North Sydney Public School Response to Submissions, (Heritage)

Curio Projects 2021, *North Sydney Public School, Response to Submissions—Heritage*, prepared for NSW Department of Education

Curio Projects Pty Ltd have been commissioned by NSW Department of Education (DoE) to prepare a Response to Submissions (RtS) report, for submissions received with regard to Heritage in relation to the SSD Application submitted for the North Sydney Public School (NSPS) Redevelopment project (SSD-11869481). This report has been prepared by Sam Cooling, Cultural Heritage Manager, and Tatiana Barreto, Architectural and Urban Design Specialist, of Curio Projects Pty Ltd.

Figure 1: Extract of previously proposed Bay Road entry (Source: Fulton Trotter)

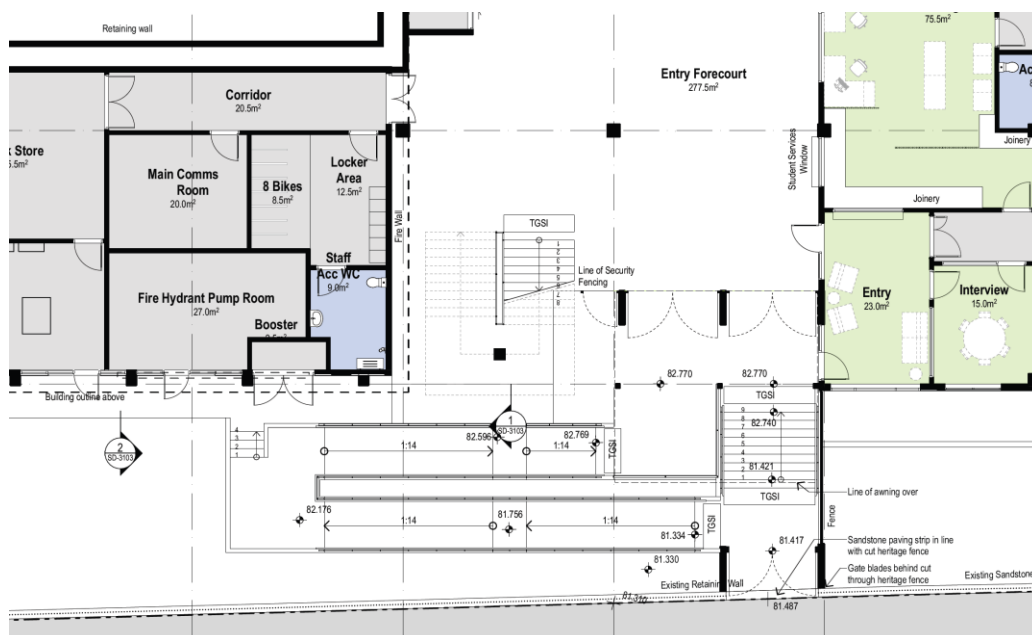
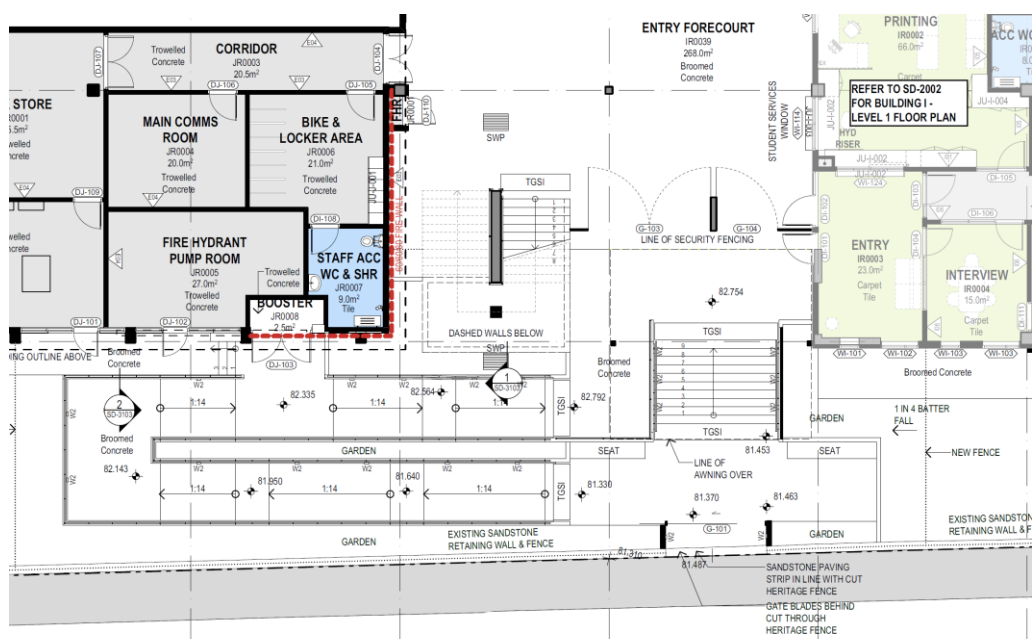
Agency/ Name	Submission Comment	Curio Response/Commentary
NSW GAO SDRP	<p><i>1) Bay Street Entry</i></p> <p><i>The rationalised ramp (providing parity with the stair for 'arrival' at the building interface) and addition of the awning roof are noted as positives; however concerns remain regarding the overall amenity and quality of this important entry as the centrepiece of the upgrade. Further design development is recommended to address the following:</i></p> <ul style="list-style-type: none"> <i>Notwithstanding concerns about minimising the opening in the heritage fence, the reduced stair and gate width have significantly impacted the welcoming and generous nature of the site entry. The reduced stair is no longer aligned with the width of the entry awning and width of the</i> 	<p>Noted, and additional discussion/commentary as follows.</p> <p>While it is recognised that these two points commence with 'Notwithstanding impacts to the heritage fence', it is still relevant to re-iterate the conclusions of the heritage impact assessment regarding impacts (both physical and visual) proposed by the development to the heritage fence. As stated in the SSDA HIS (Section 7.3.1):</p> <p><i>...the creation of the new entrance point will have a negative physical impact in the removal of a section of the original fabric of the heritage fence (c.3500mm in width), on balance, the location of the new entrance in the proposed location will create the new required southern DDA site access without proposing any impact to the original southern former Crow's Nest House gate.</i></p> <p><i>In order to minimise the physical impact of the new entrance, it is recommended that the detailed design of the new entrance ensure that the amount of original fabric required for removal is minimised as much as possible, limited only to that necessary to accommodate the width and form required for the new entrance to meet EFSG/DDA requirements (HIS, p. 132-133).</i></p>

Figure 13: Extract of previously proposed east elevation Building I (Source: Fulton Trotter)

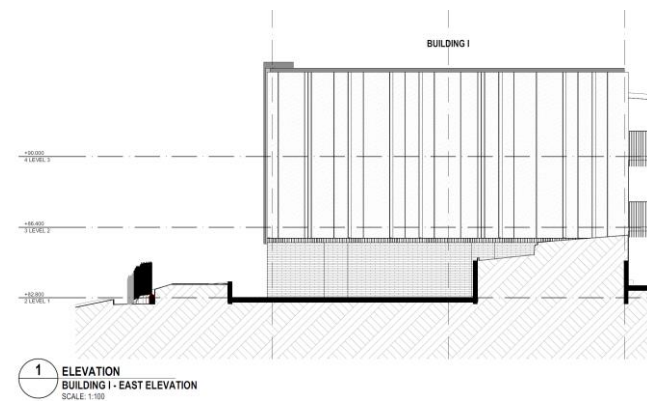
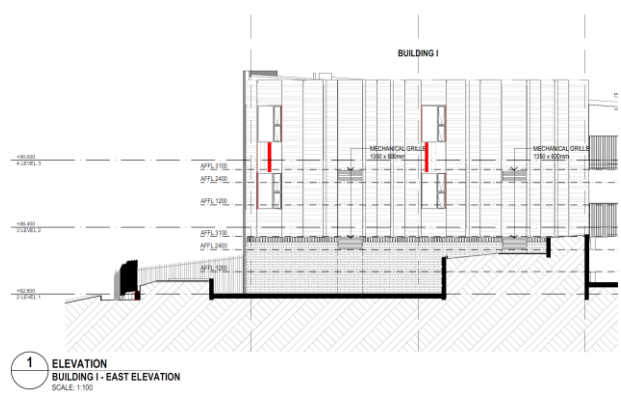
3) Façade and roof form		
	<ul style="list-style-type: none"> <i>The east elevation of the main building is not supported. This façade has full height panels without windows, the architectural expression at this end of the building (as it presents to Bay Street) is not supported as an appropriate fit with the heritage context. This includes concerns about:</i> <ul style="list-style-type: none"> <i>the expression and use of DFMA (refer above), specifically the windows providing an 'in between' scale consistent with the aforementioned heritage principle.</i> 	<p>Noted, and additional discussion/commentary as follows.</p> <p>The amended design includes window openings to the eastern façade to help to soften the overall presentation of the façade within the heritage context and to make it more cohesive with the remainder of the building. The windows represent an element of transparency on the façade, creating a smoother transition between modern and heritage fabrics and allowing users to appreciate and visually interact with the original building daily.</p> <p>Further, the amended design has revisited the façade colours and textures to also soften the impact and tonal perception of the façade. The proposed skin cladding colour results from the combination of three different colours, creating a more organic and natural finish to the material that better relates to the sandstone colour of the heritage items.</p> <p>Overall, the proposed alterations to the eastern façade are assessed to have a positive visual impact on the heritage context of the building as they will improve the visual connection between modern and heritage fabrics, creating a cohesive, sympathetic and smooth transition between them.</p>
